March 4, 2022

RE: Meadoworks Development Plan and Final Plat – 2nd Review Comments
City File # AR DP 21-00591, AR FP 21-00592, AR FP 21-00593, AR FP 21-00594, AR FP 21-00595

In response to the updated March 1, 2022 Review Comments in regards to the Meadoworks Development Plan and Final Plat we have provided the below responses in red and associated revised drawings.

PRELIMINARY
LANDSCAPE PLAN

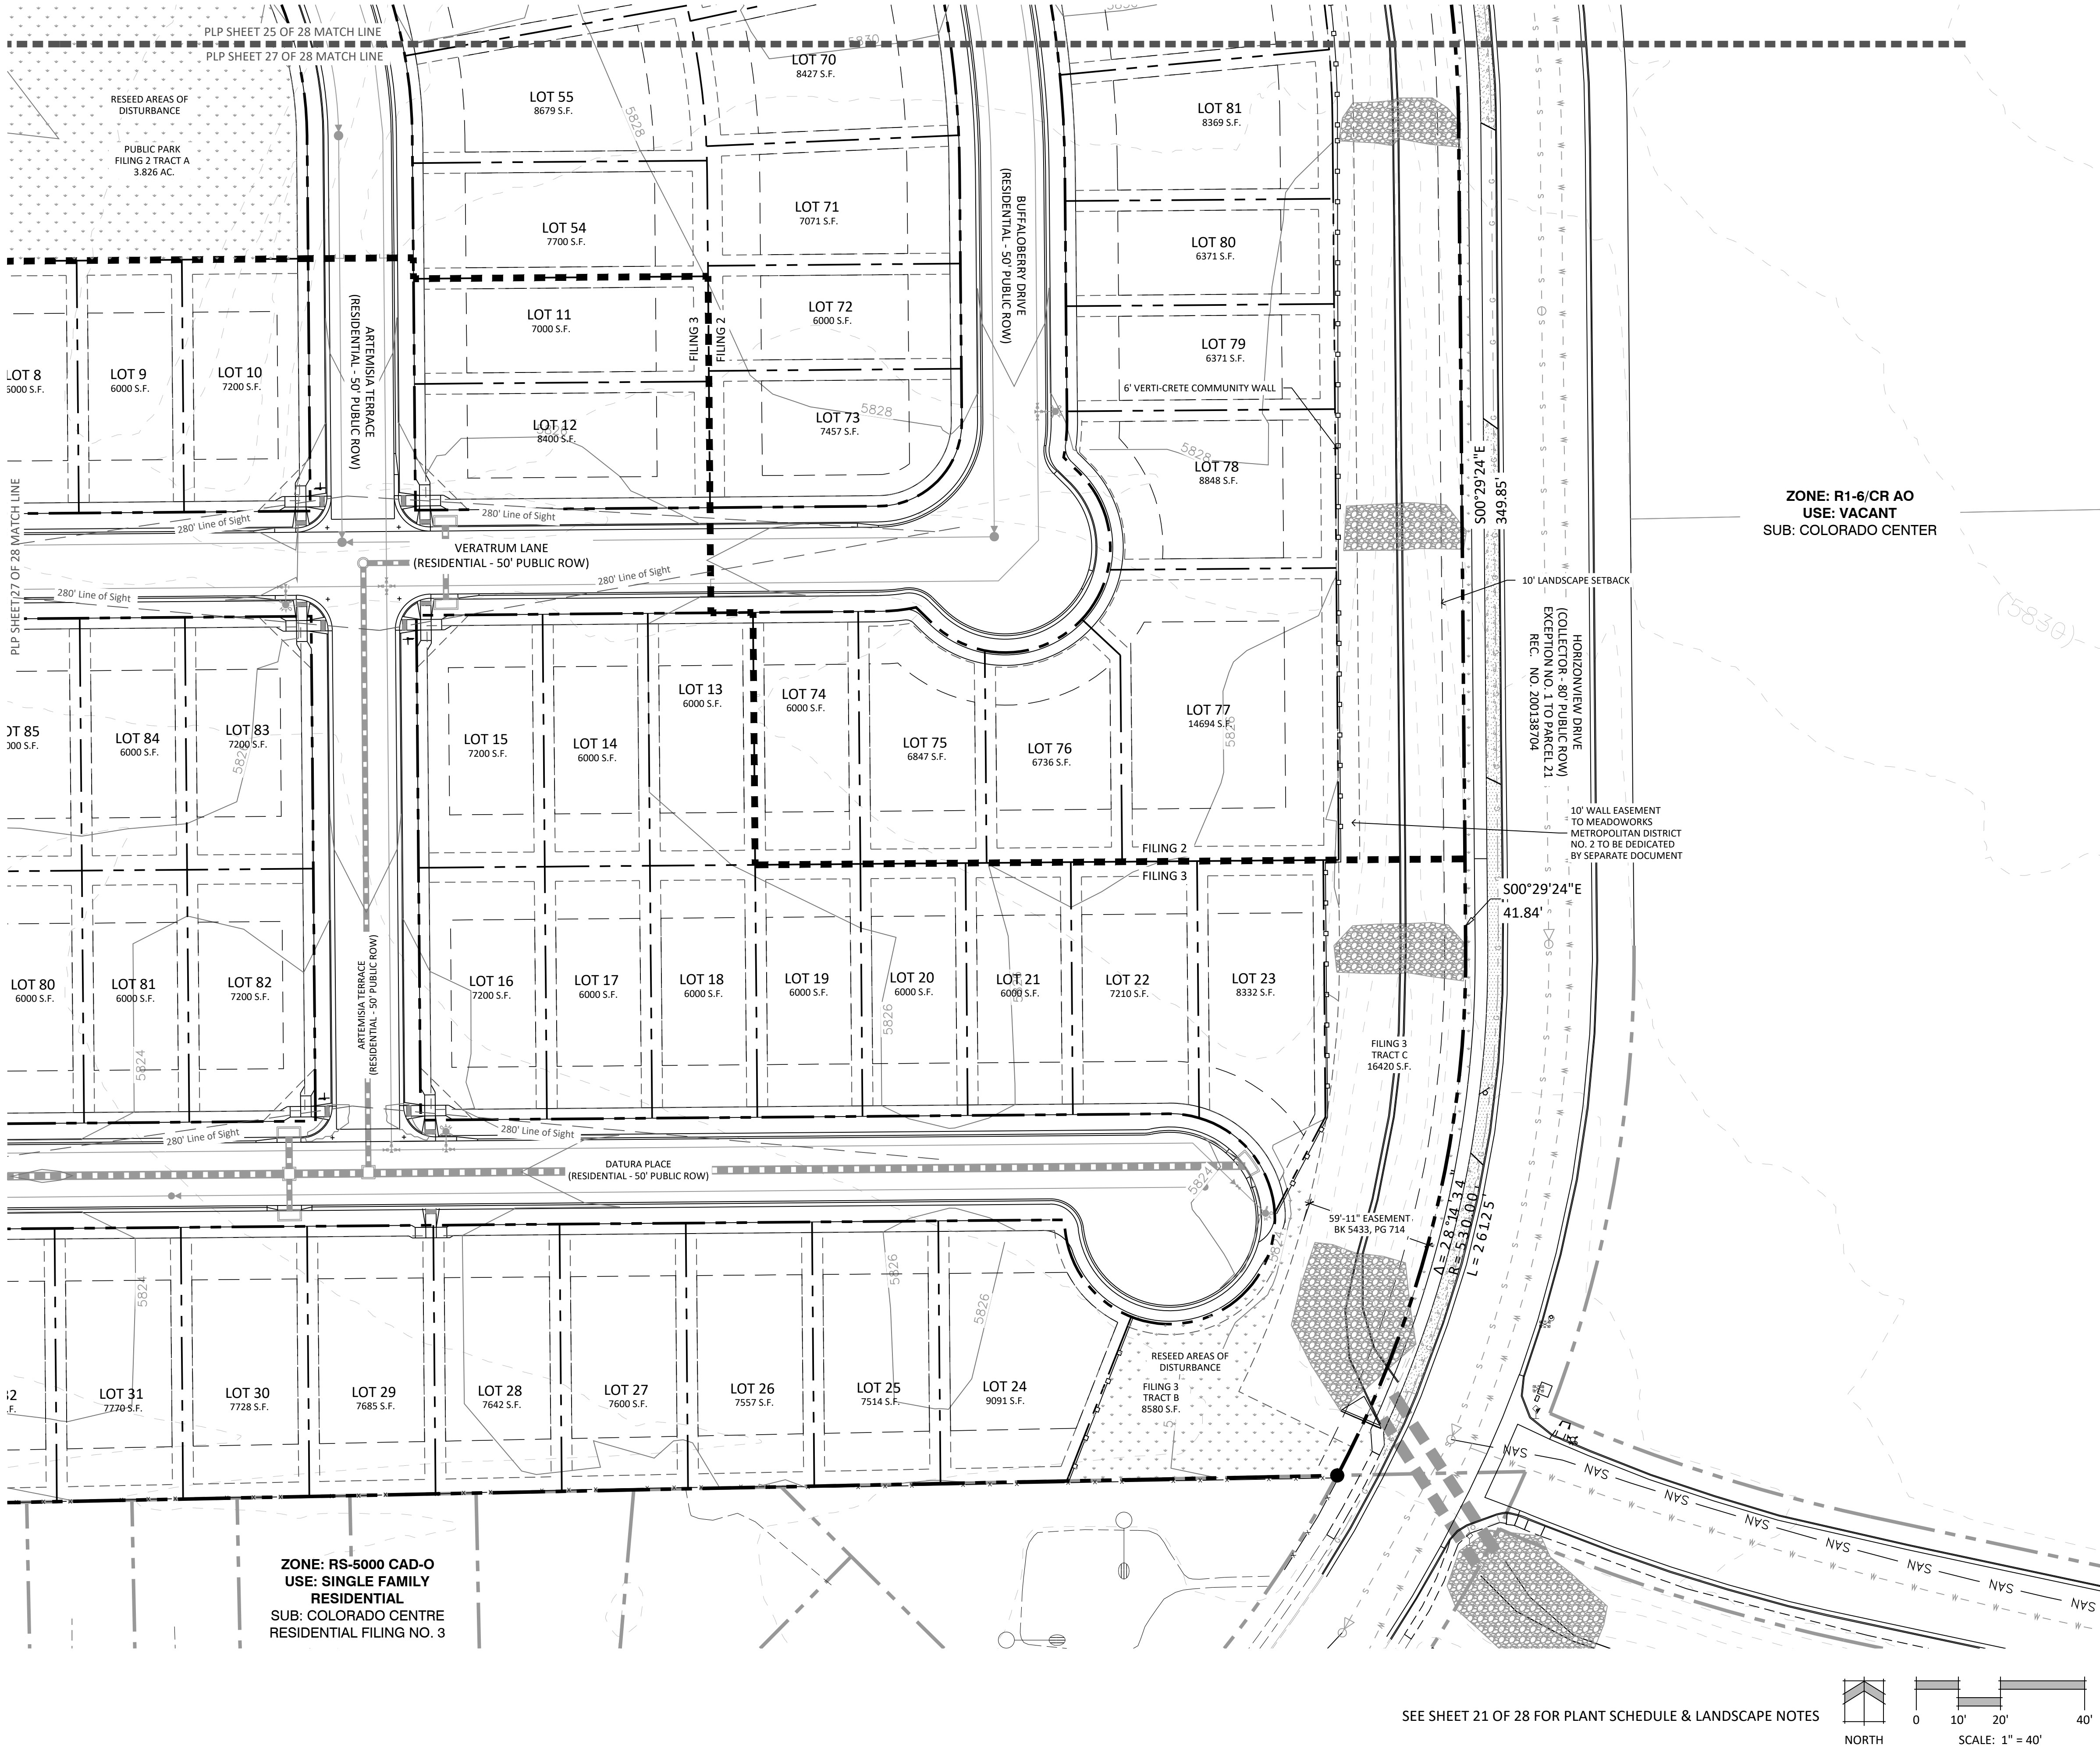
2. Not Addressed Sheet 4,6, 10,12, 16, 18, 26: Clearly label the maintenance access to the proposed EDB on all applicable sheets, including Landscape Plans. Ensure maintenance access meets criteria (refer to DCM volume 1, chapter 13, section 5.16 for maintenance access requirements). Sheet 6, 16, 18, 26, are missing access road label.
Pond maintenance access has been called out on all applicable sheets.

7 6' VERTI-CRETE COMMUNITY WALL

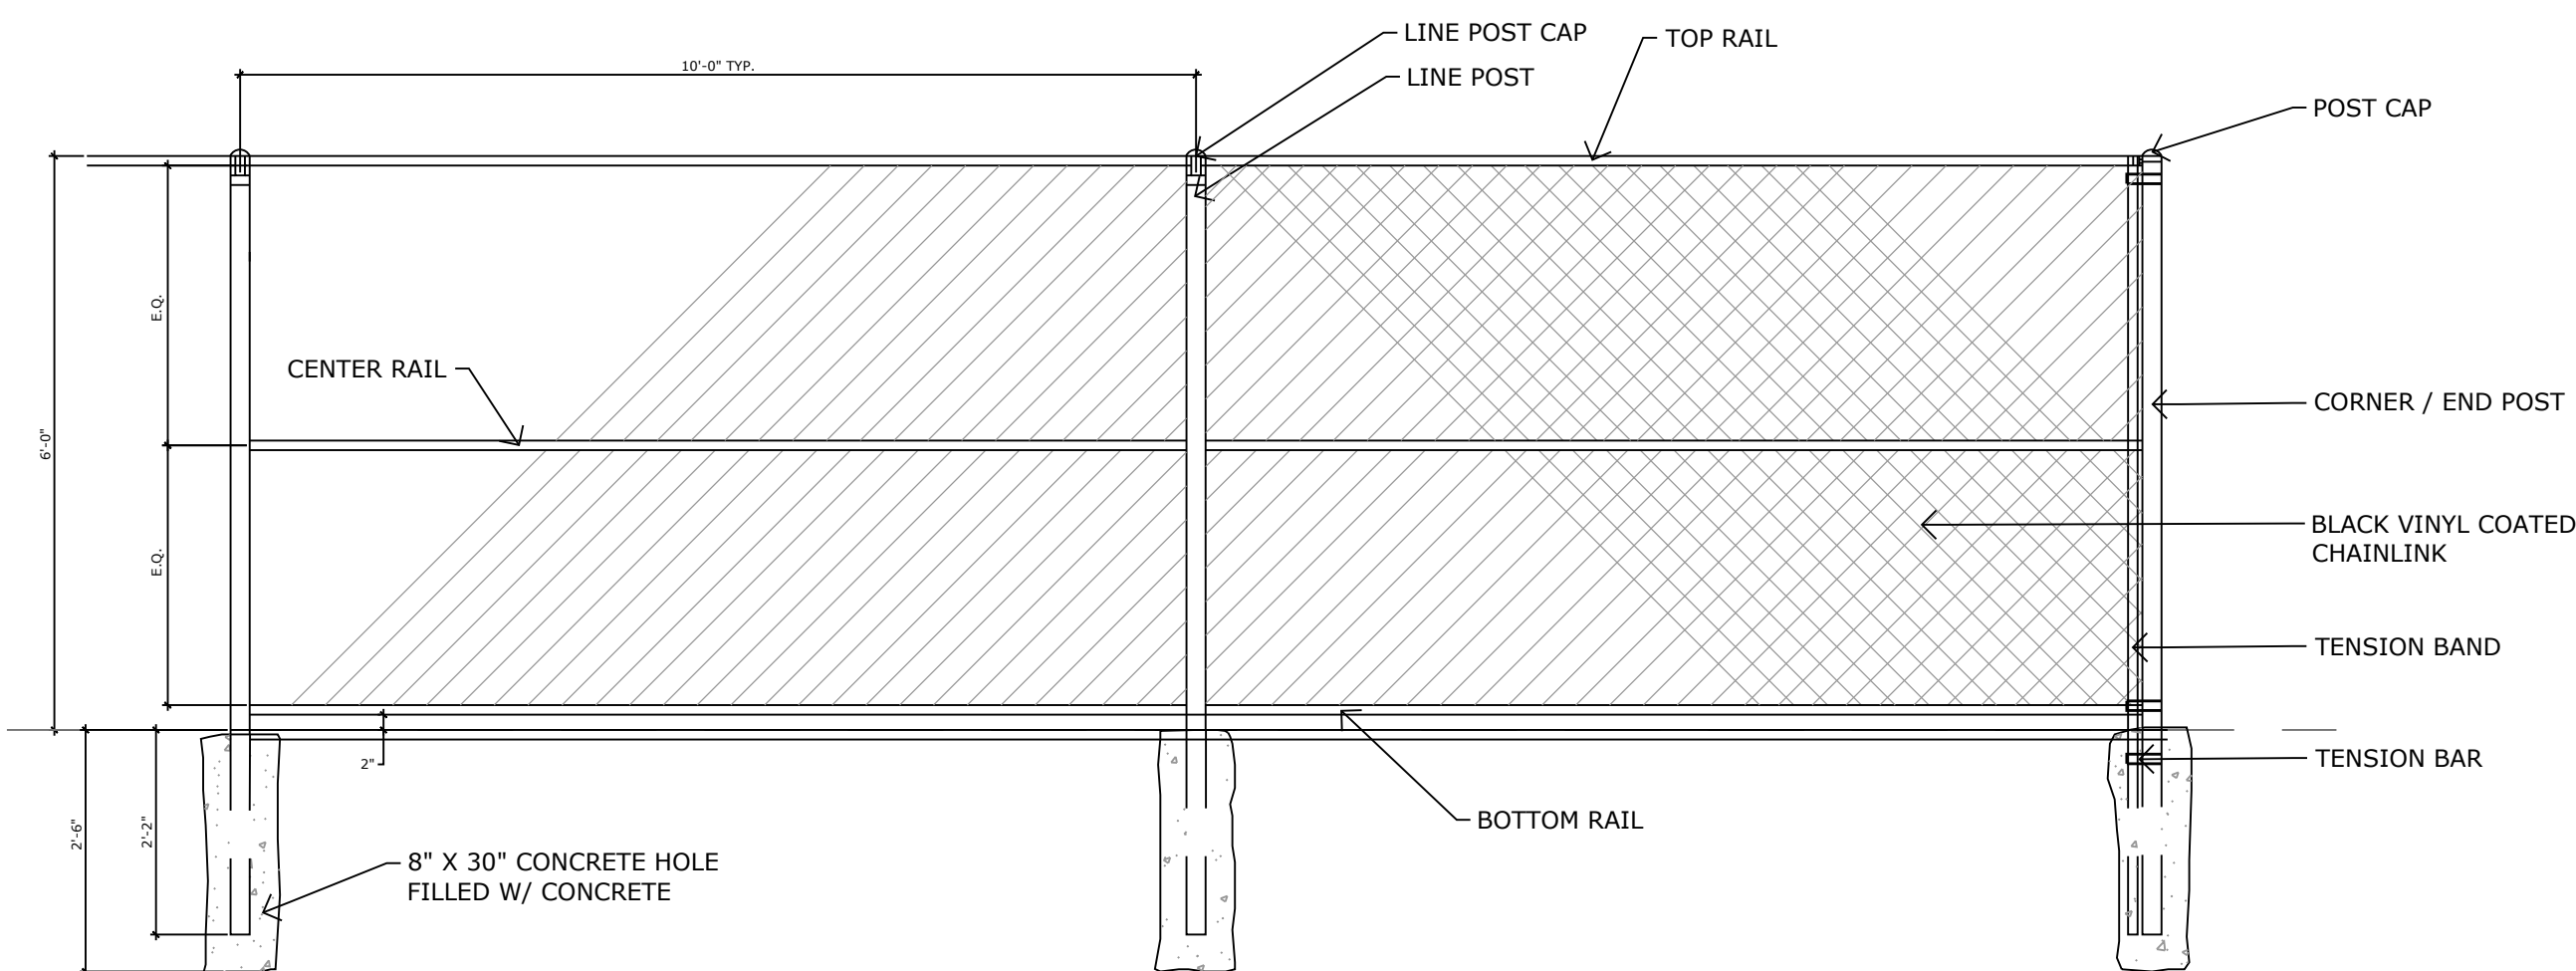
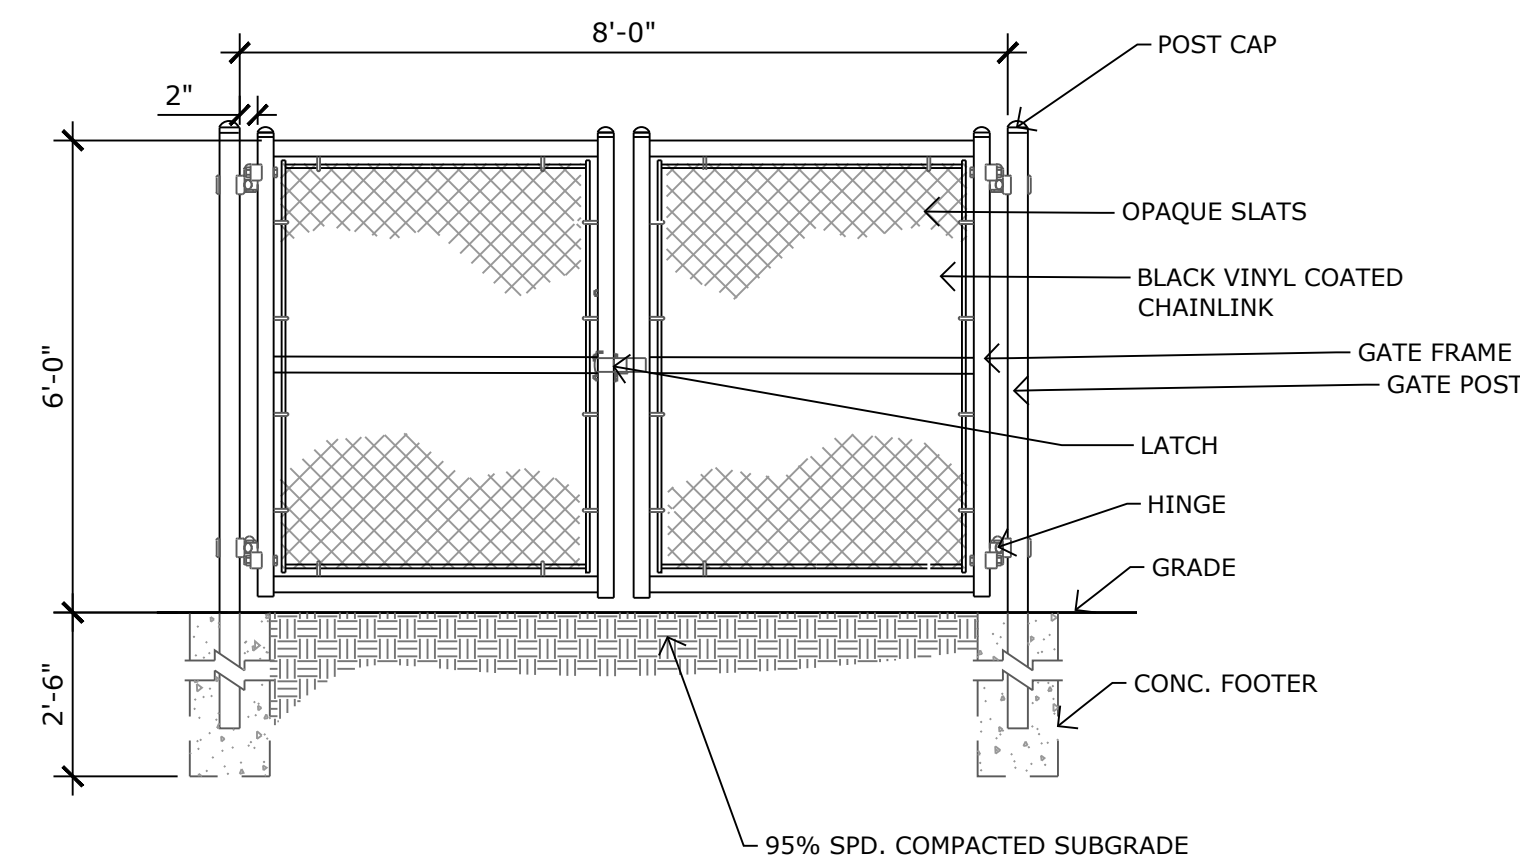
- b. Label the sound wall and dog park fencing on the landscape sheets. (PLP # 1.j) Also if any other fencing is proposed, provide a detail, and call out the locations on the plans. Currently only the sound wall is shown around lots (Example adjacent to Horizonview Drive and Marksheffel Blvd)
All of the proposed fencing is shown on the DP and PLP sheets. Details for each are provided with the landscape details, sheet 28 of 28.
